Comments for Planning Application 24/00171/OUT

Application Number: 24/00171/OUT

Address: 24 High Street Cullompton Devon EX15 1AA

Proposal: Outline for the erection of a dwelling with some matters reserved and additional parking for No 24 High Street

Proposed Site Plan
scale 1:200

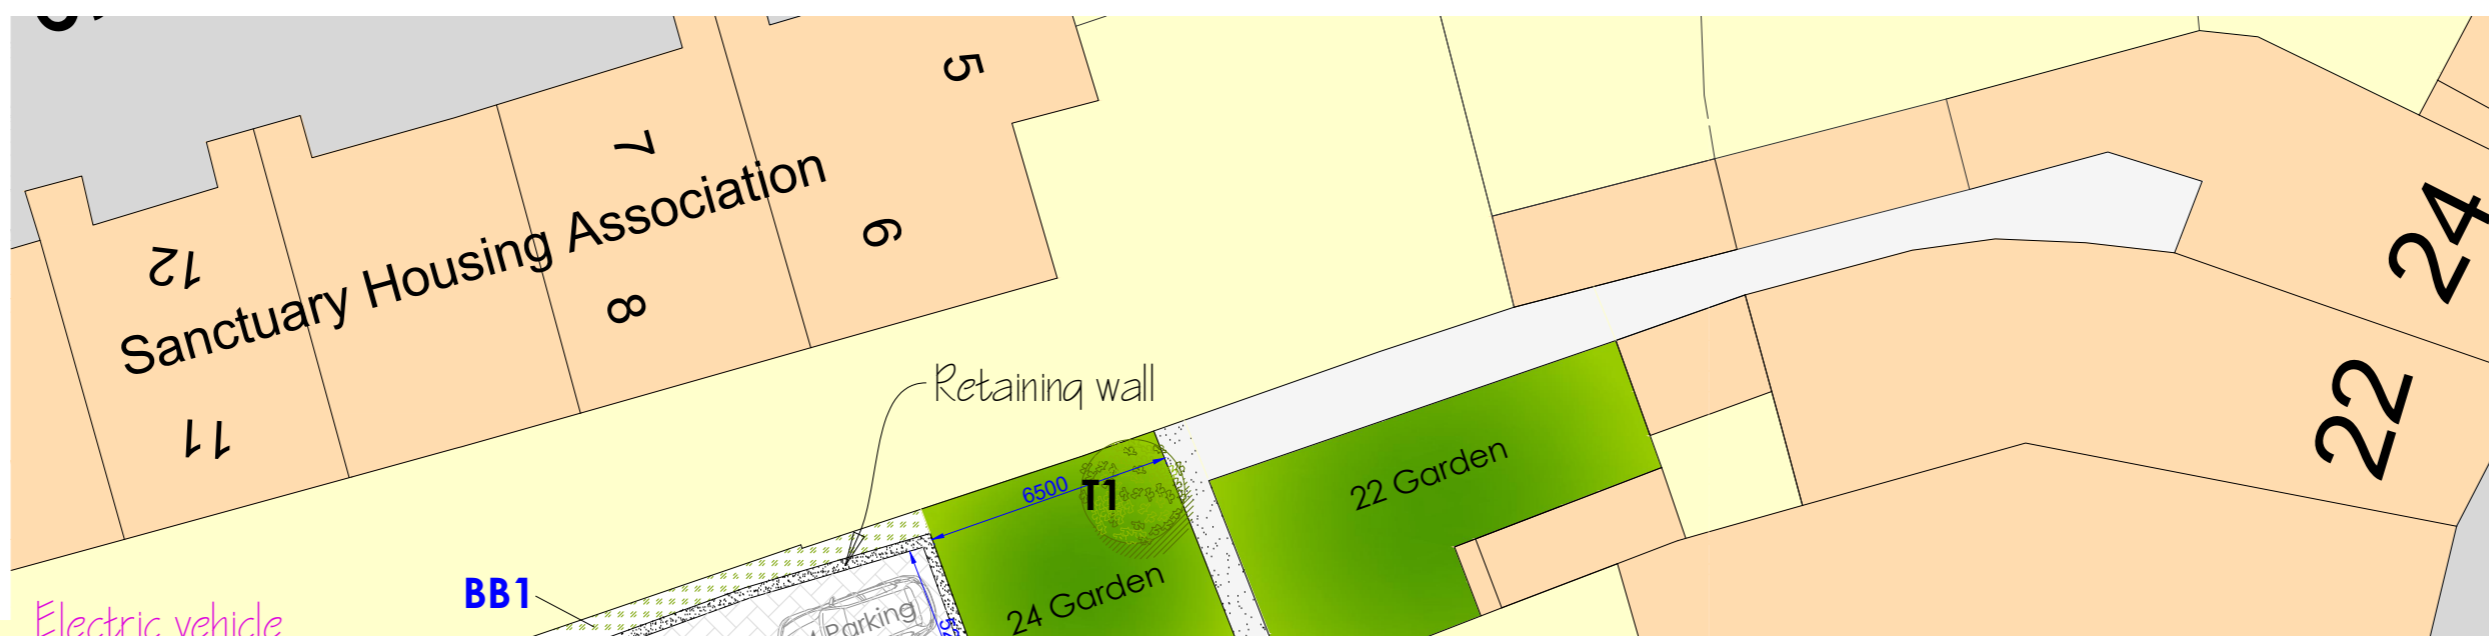
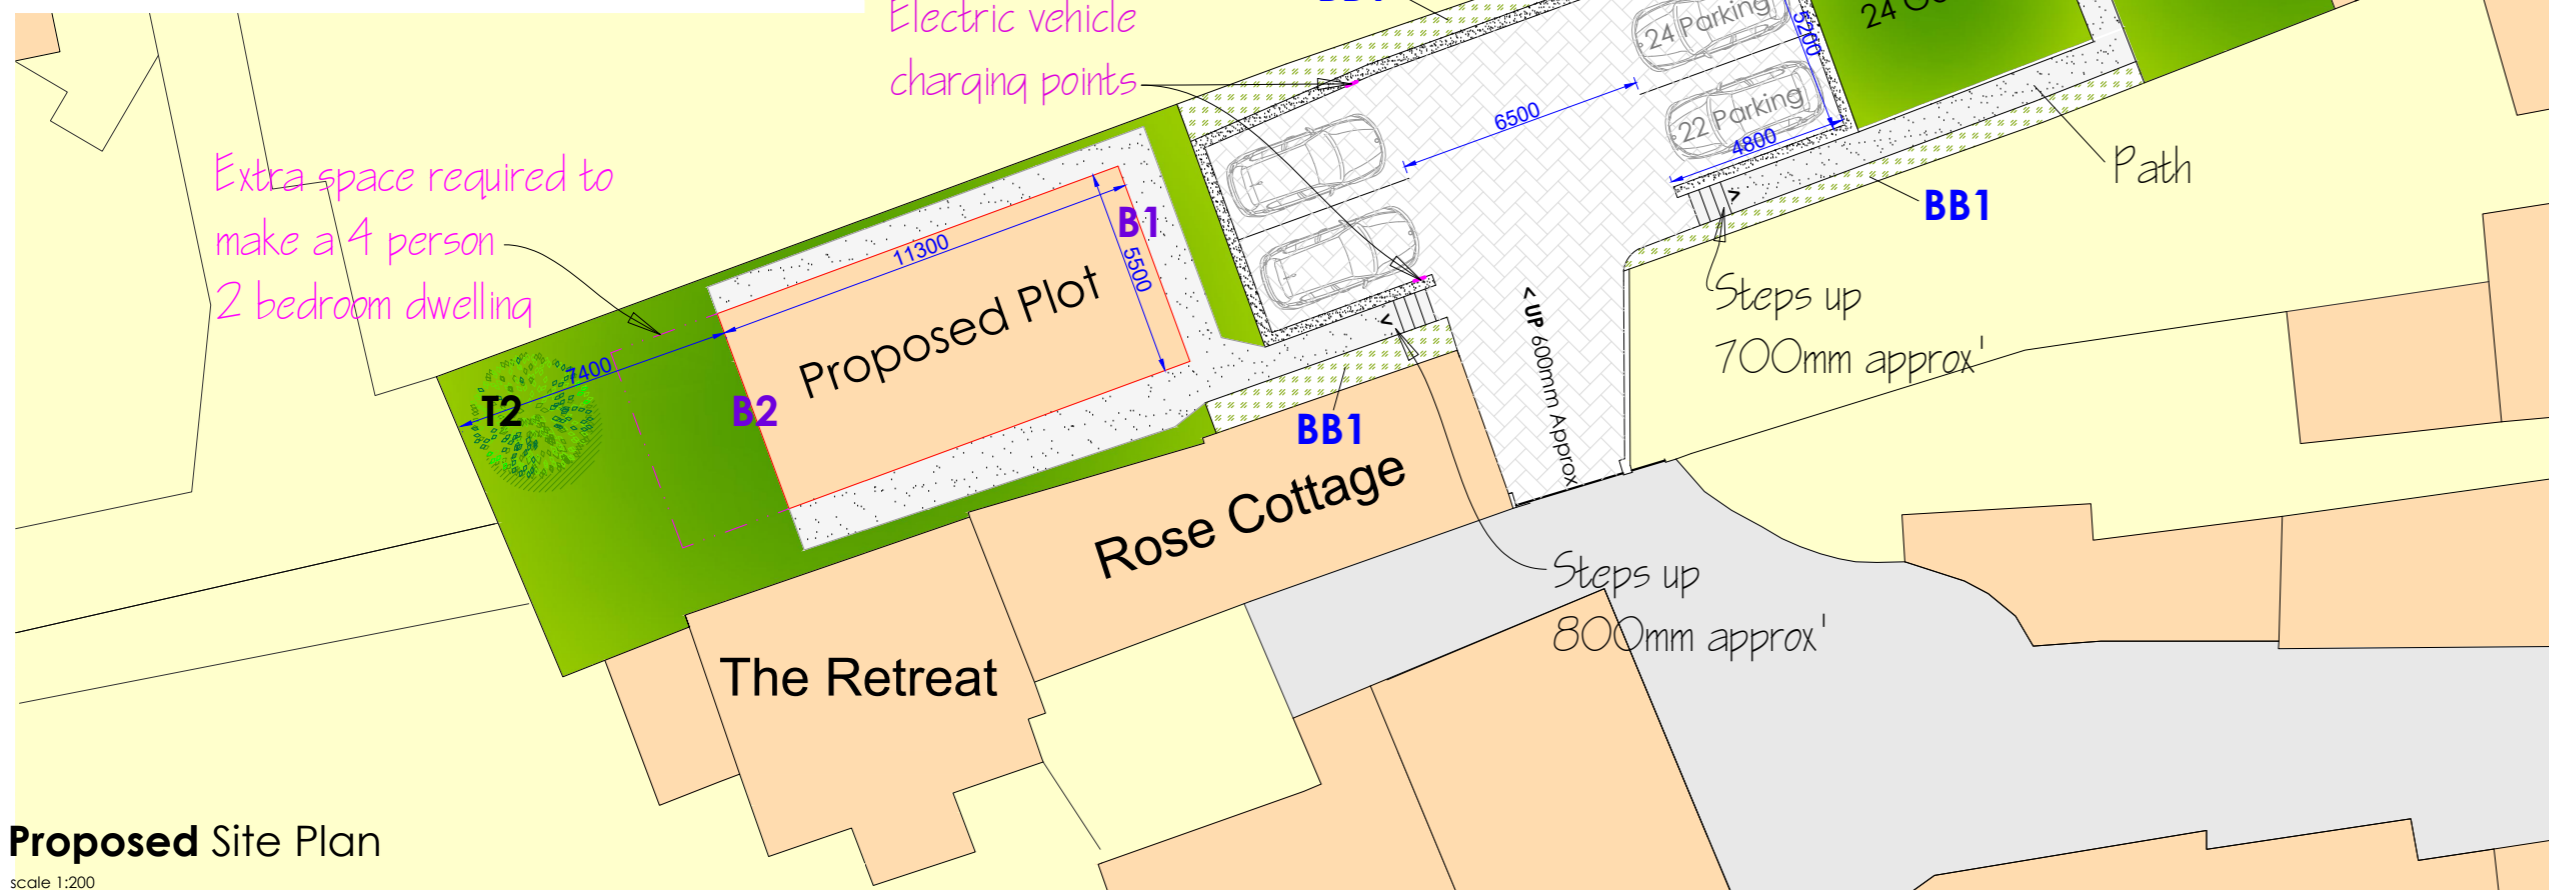
The area in front of the tiny garage/store is not only a pedestrian access to the cottages on the left, it is also a common space used as an amenity area for parking, unloading and loading for both residents and businesses in St John Court.

Regarding the proposed parking area, it does not look like they have enough room to turn their vehicles around within the application site. There will be an increase of traffic movements through the common area from notionally one vehicle to four vehicles, along with the dangers that flow from this especially to pedestrians in the common area.

I would strongly recommend a site visit by the planning case officer and Highways. This is a hazardous scheme, with a precarious route to their proposed car park with blind corners. There is a high risk of damaging our property Gidley Coach House and neighbouring properties by vehicles entering and exiting this cramped space.

The addition of an 'internal road' over the common area would have a negative impact on the residents, visitors, businesses and historic courtyard character of St John court.
